STATEMENT OF RESPONSE TO AN BORD PLEANÁLA'S CONSULTATION OPINION

PREPARED FOR COINDALE LTD.

IN RESPECT OF A
PROPOSED RESIDENTIAL DEVELOPMENT
AT ACADEMY STREET NAVAN, CO. MEATH
NOVEMBER 2019

Client:	Coindale Ltd.
Project Title:	Navan Belmont SHD
Document Title:	Statement of Response to An Bord Pleanála’s Consultation Opinion
Document No:	17160SRABP

DRAWING TITLE:
**SITE SERVICES LAYOUTS
 PROPOSED PUBLIC LIGHTING LAYOUT (B)
 SHEET 2 OF 3**

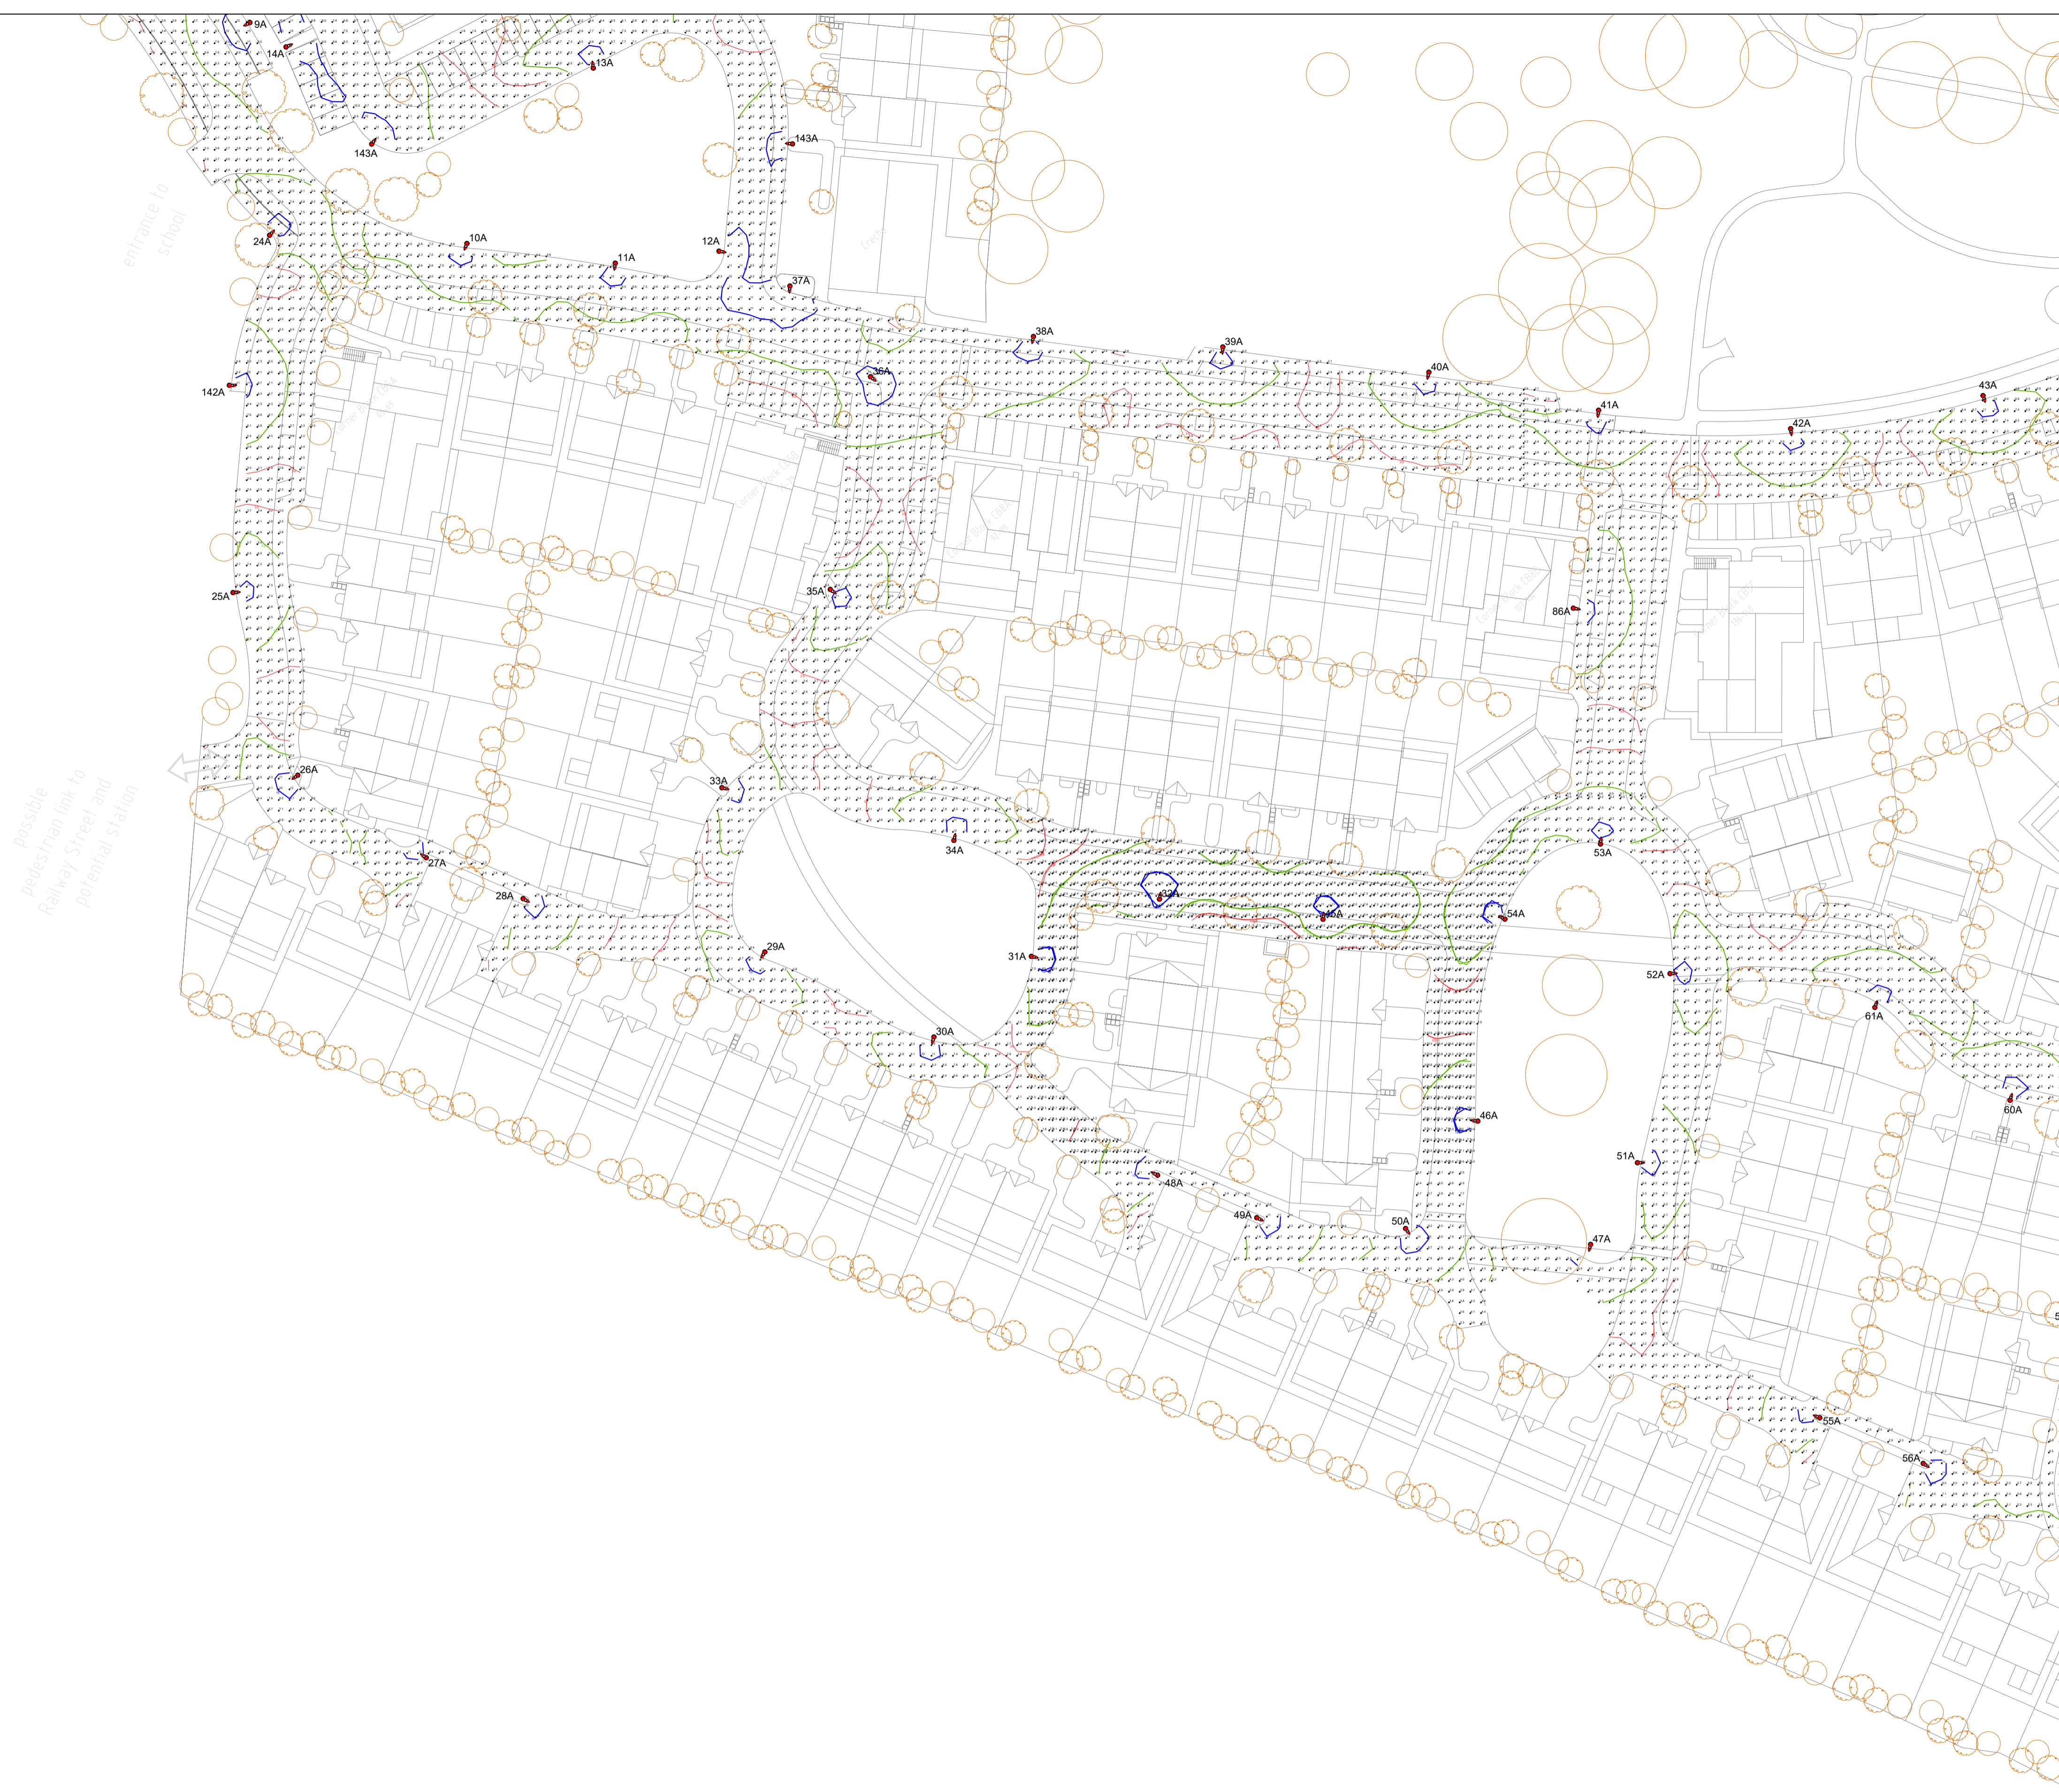
- *Details of public lighting.*
- *Details of Part V provision clearly indicating the proposed Part V units.*
- *A plan of the proposed open space within the site clearly delineating public, semi-private and private spaces.*

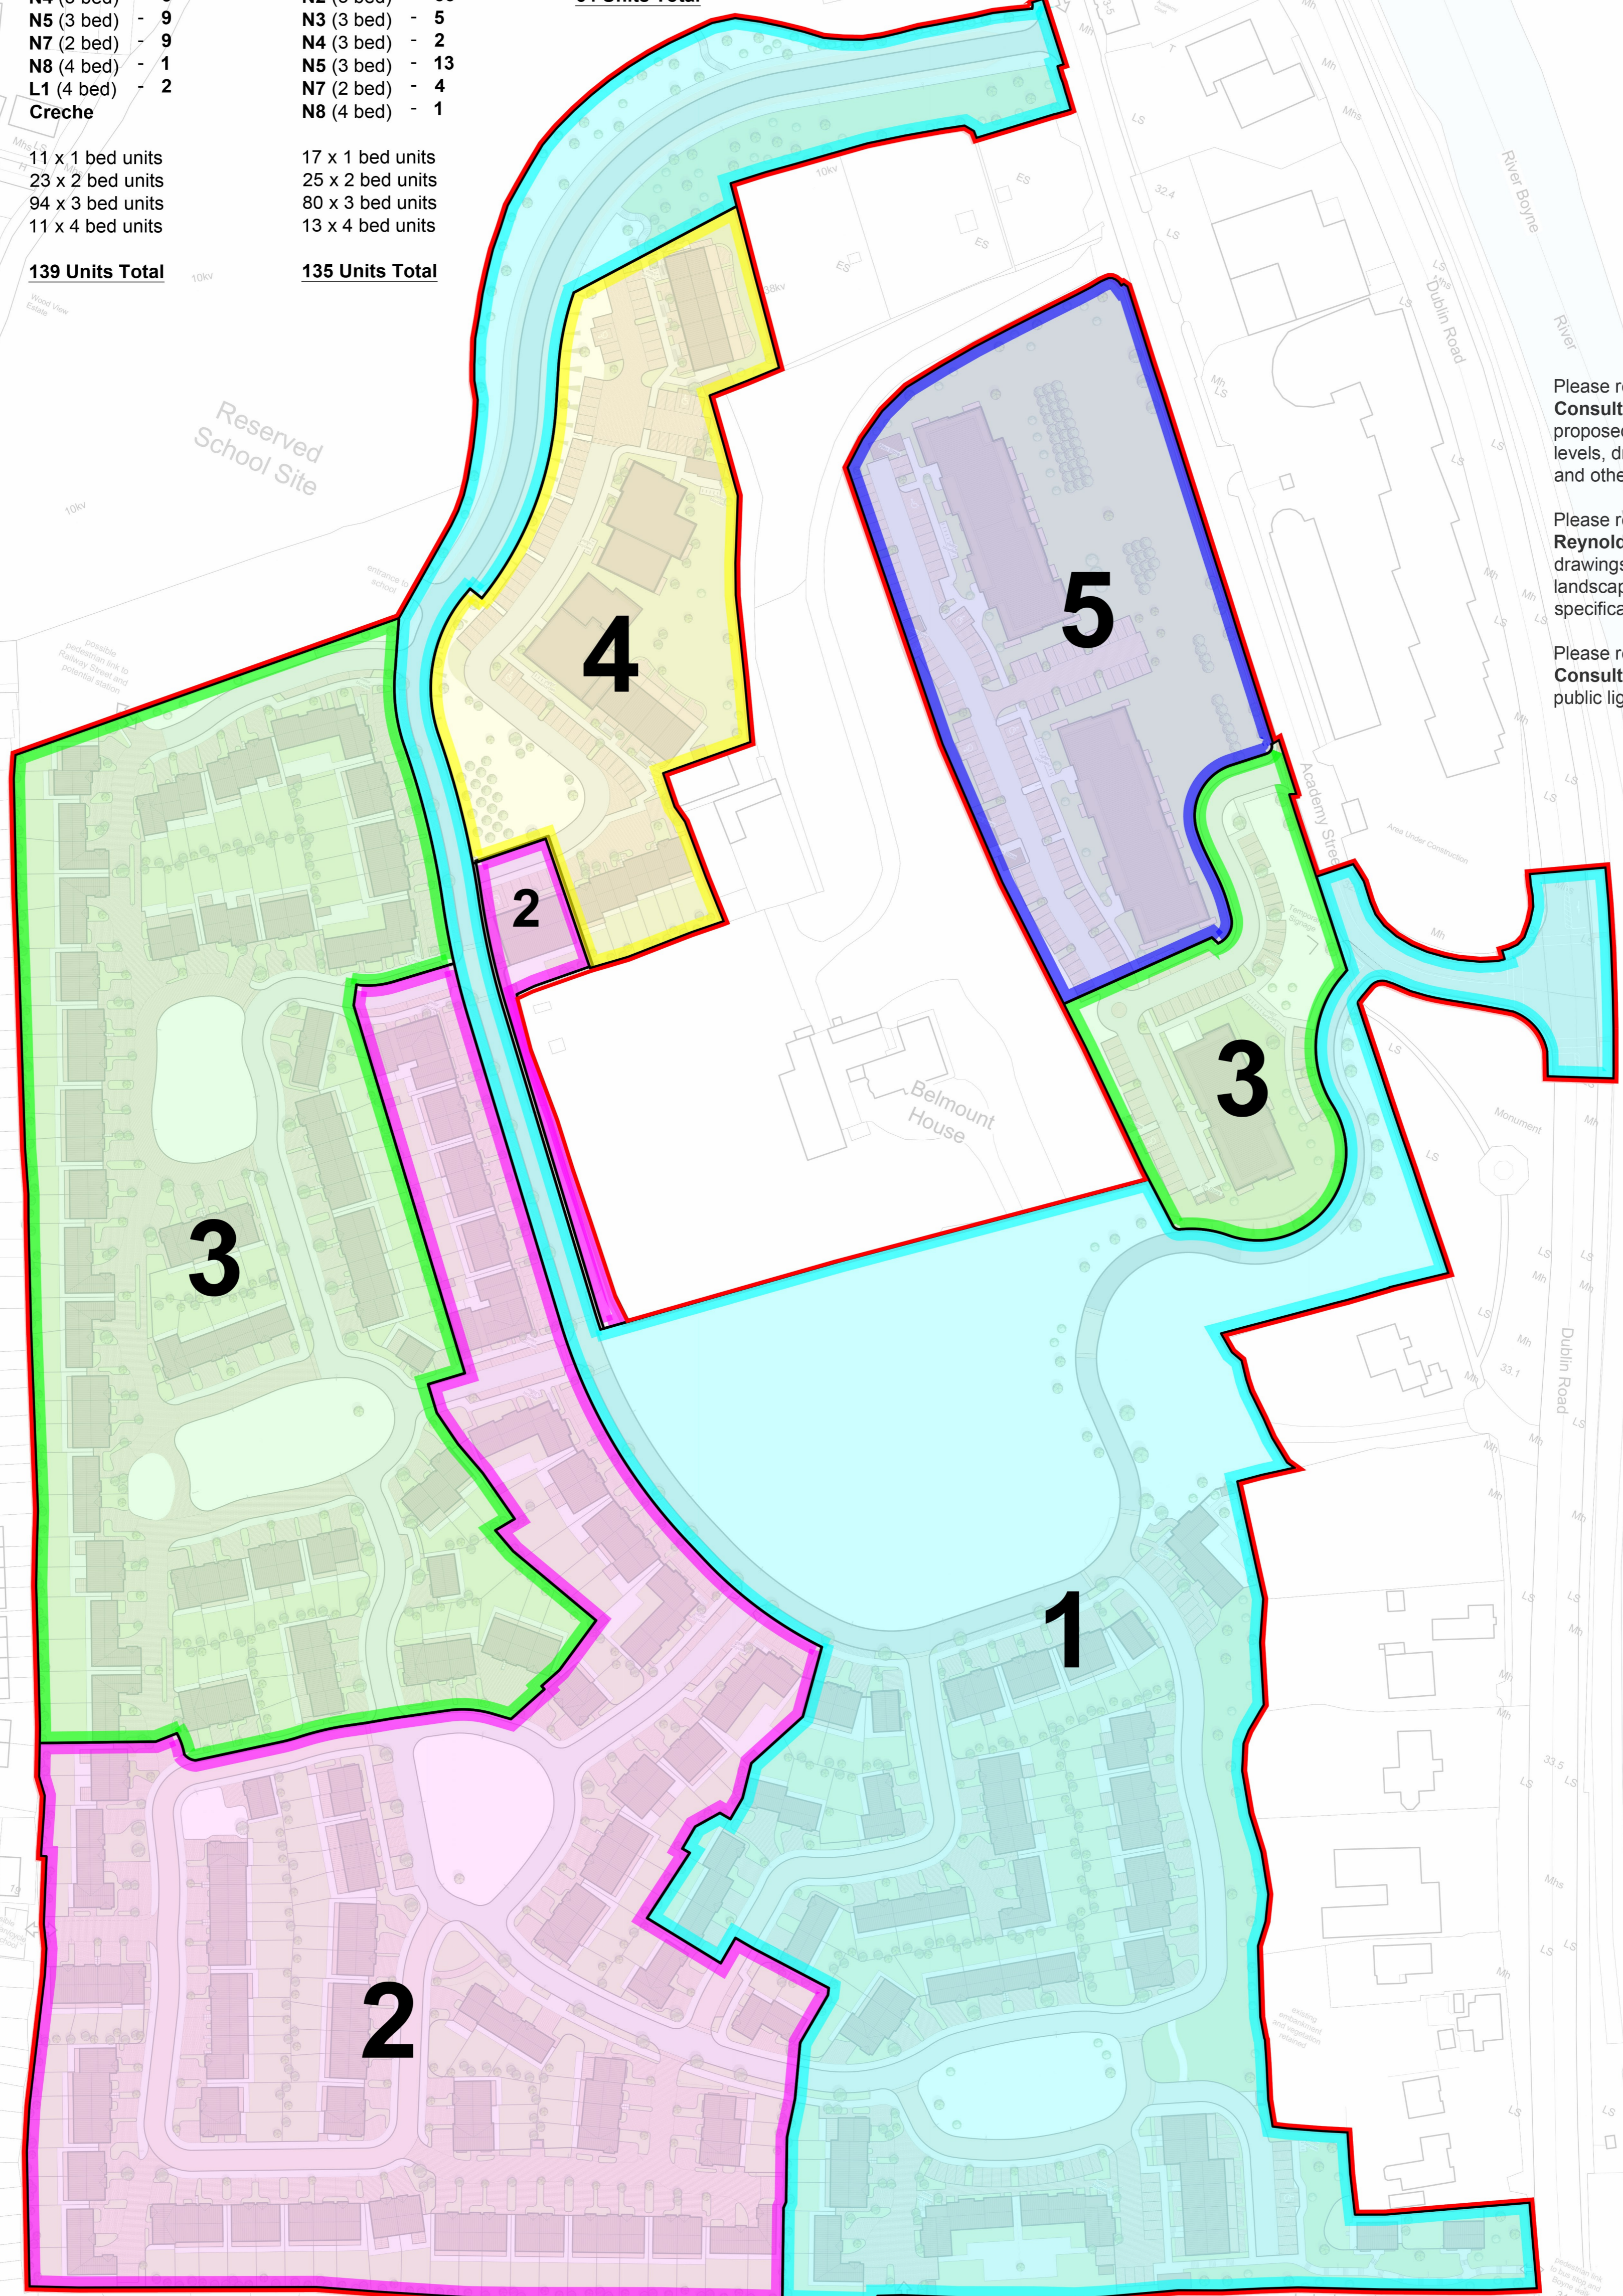
- *A detailed phasing plan for the proposed development should be provided.*
- *A site layout plan clearly indicating what areas are to be taken in charge by the Local Authority.*
